**Fenwick Solar Farm
EN010152**

Schedule of Changes to the Draft Development Consent Order
Document Reference: EN010152/APP/8.18

July 2025
Revision Number: 01

SHEET 10

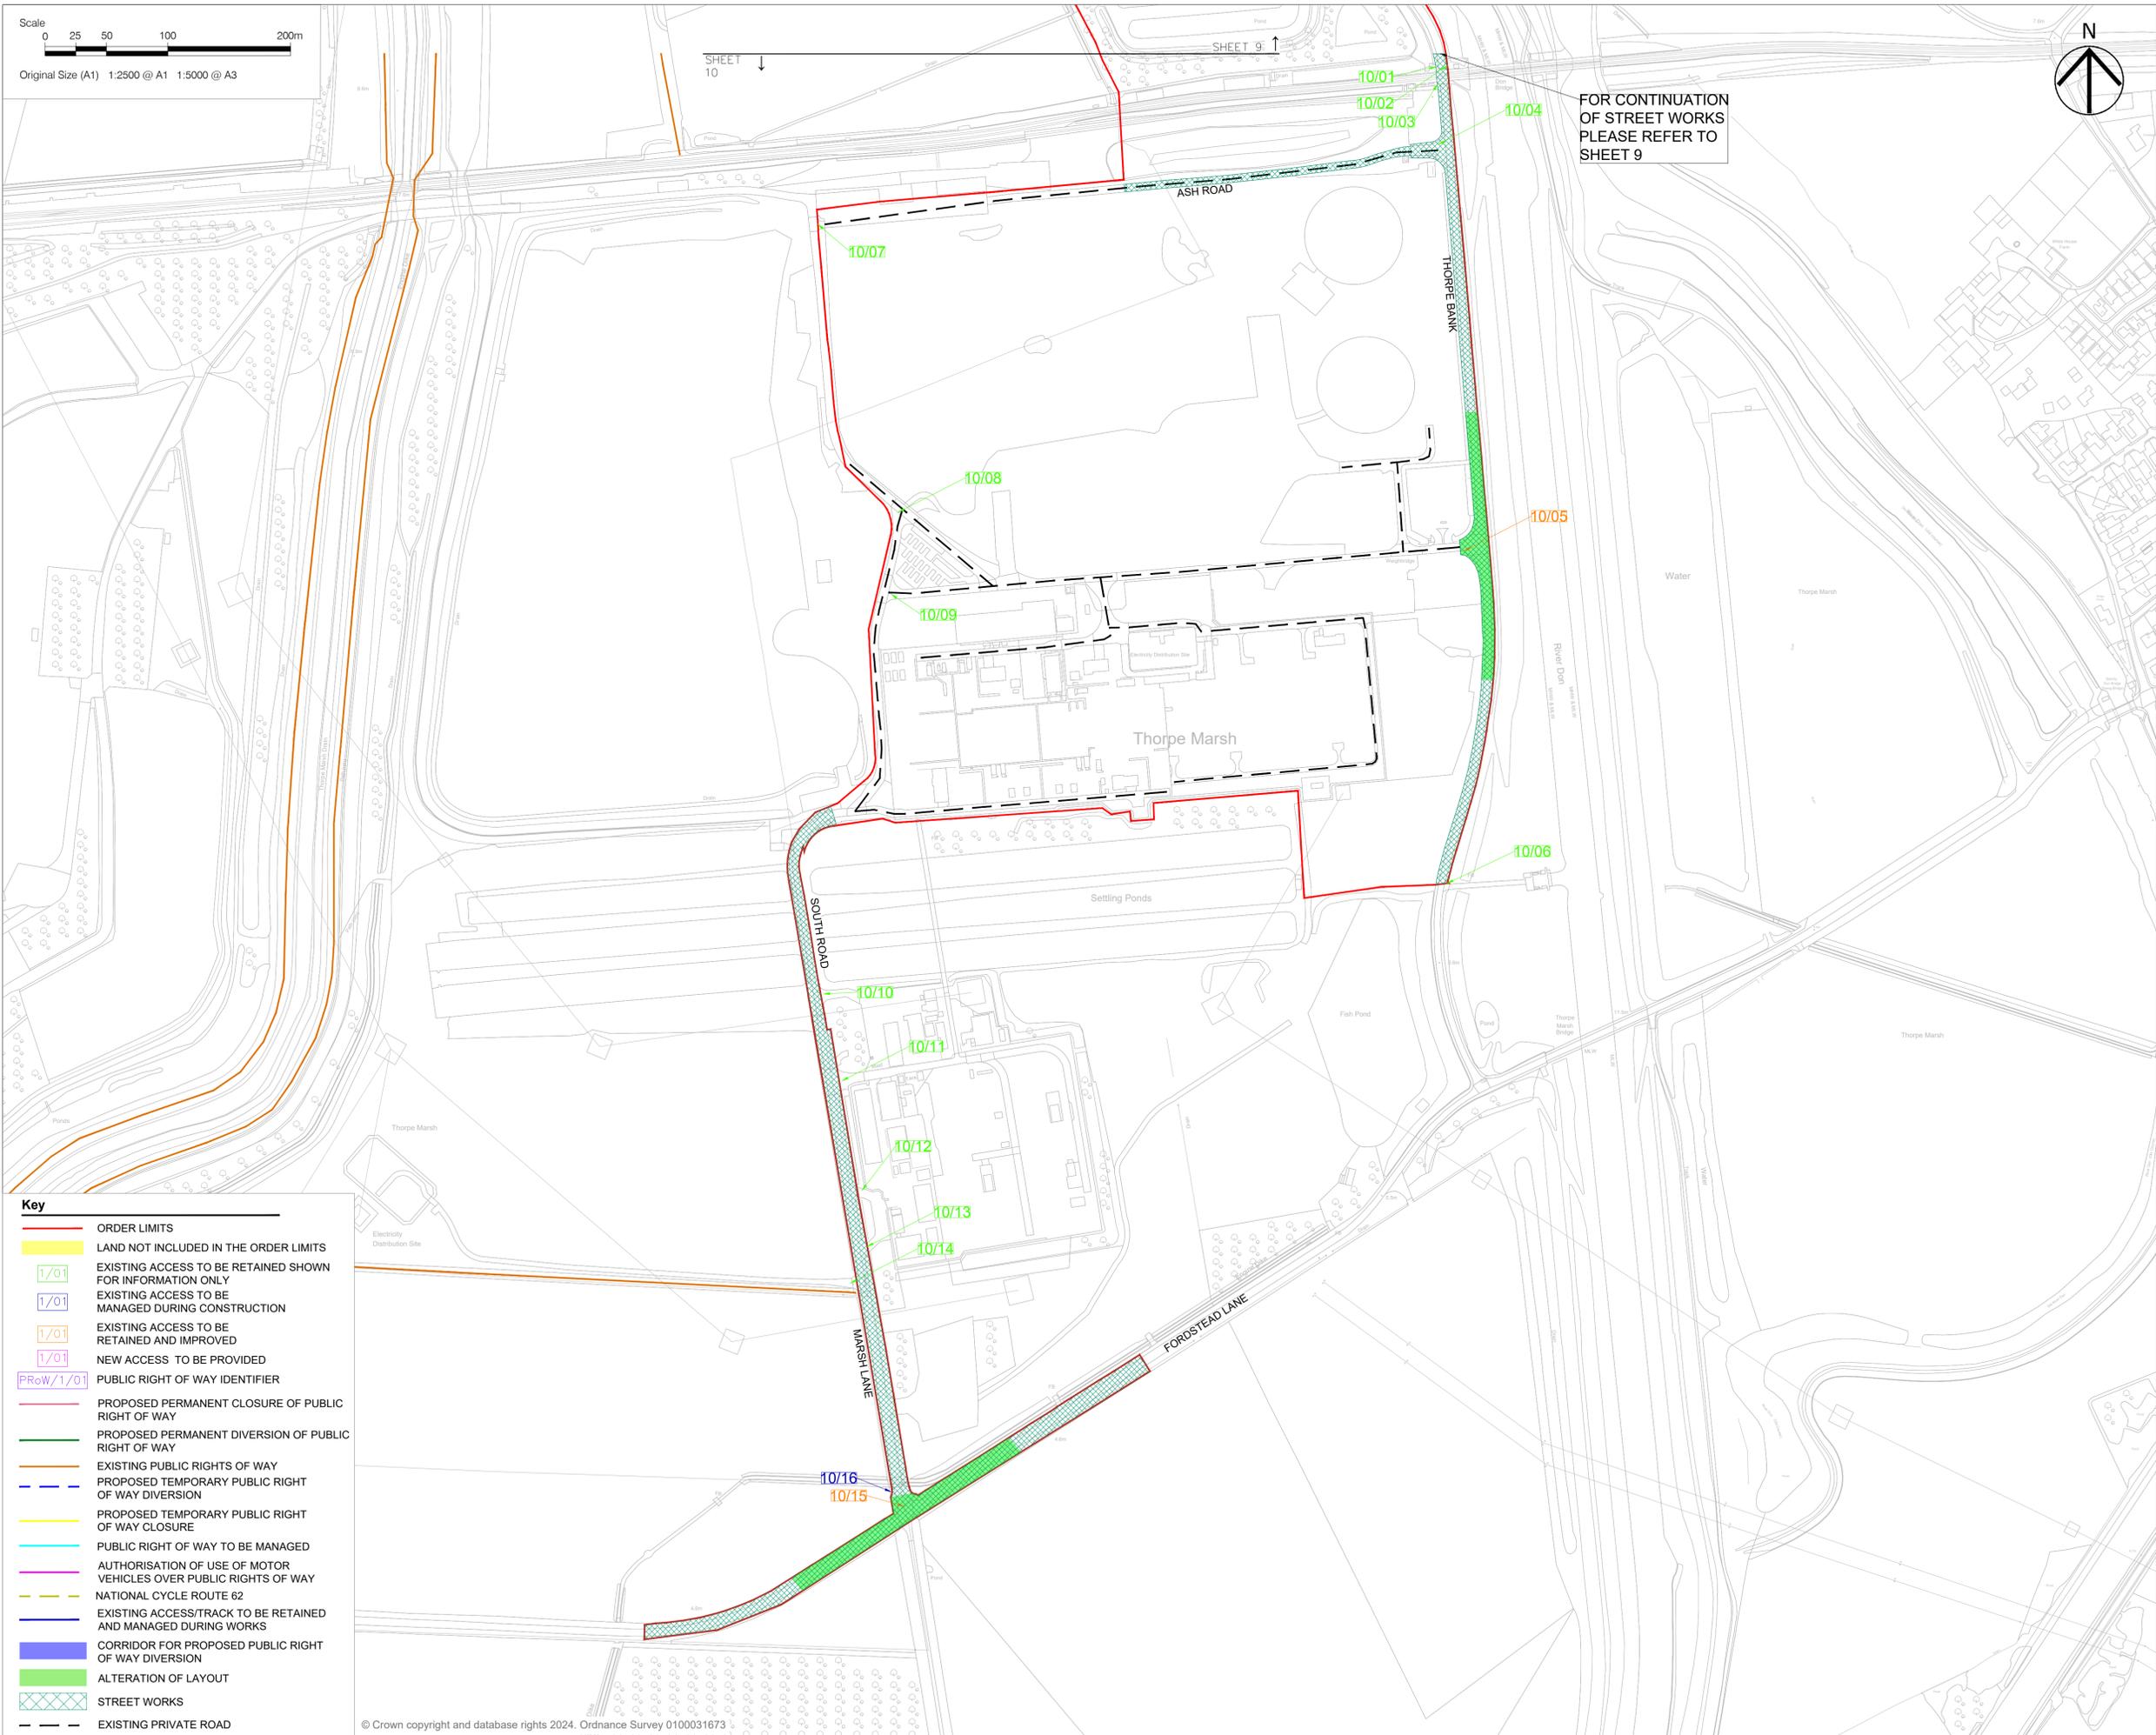
Reference	Change	Reason for Change	Deadline								
	for approval a decommissioning environmental management plan for that part. Such approval to be in consultation with the Environment Agency.										
Schedule 4 (Streets subject to Street works)	Deletion of streetworks area: <table><tr><td>City of Doncaster Council</td><td>Ash Road</td><td>Street works to facilitate cable works and carriageway surface repairs for the length shown in green patterned hatching within proximity of access 10/04 on Sheet 10 of the streets, rights of way and access plans</td></tr></table>	City of Doncaster Council	Ash Road	Street works to facilitate cable works and carriageway surface repairs for the length shown in green patterned hatching within proximity of access 10/04 on Sheet 10 of the streets, rights of way and access plans	Deletion agreed with CDC and associated changes to Streets Rights of Way and Access Plans.	3

City of Doncaster Council	Ash Road	Street works to facilitate cable works and carriageway surface repairs for the length shown in green patterned hatching within proximity of access 10/04 on Sheet 10 of the streets, rights of way and access plans									
Schedule 6 (Streets and Public Rights of Way)	Various amendments within tables to correct typos and delete incorrect row regarding use of motor vehicles on Moss 20.	Amendments throughout this Schedule to correct typos and delete the incorrect capturing of Moss 20 within the schedule enabling use of motor vehicles, as per comments received from CDC PRoW Officer in direct discussions.	1								
Schedule 6 (Streets and Public Rights of Way) Part 6 – Permanent Closure and Diversion of Public Rights of Way	Addition of new row for minor closure of Fenwick 10 <table><tr><td>(1) Area</td><td>(2) Public right of way to be closed</td><td>(3) Extent of closure</td><td>(4) New public right of way to be substituted/provided</td></tr><tr><td>City of Doncaster Council</td><td>Fenwick 10</td><td>The Public Right of Way between PRoW 04/05 and PRoW 04/09 on the streets, rights of way and access plans</td><td>The Public Right of Way between PRoW 04/05 and PRoW 04/08 on sheet 4 of the streets, rights of way and access plans.</td></tr></table>	(1) Area	(2) Public right of way to be closed	(3) Extent of closure	(4) New public right of way to be substituted/provided	City of Doncaster Council	Fenwick 10	The Public Right of Way between PRoW 04/05 and PRoW 04/09 on the streets, rights of way and access plans	The Public Right of Way between PRoW 04/05 and PRoW 04/08 on sheet 4 of the streets, rights of way and access plans.	Addition of new closure of a small part of Fenwick 10 per request from CDC PRoW Officer as part of the tidying up of the superfluous “dogleg” arising from the diversion and stopping up of Sykehouse 29 through Bunfold Shaw.	1
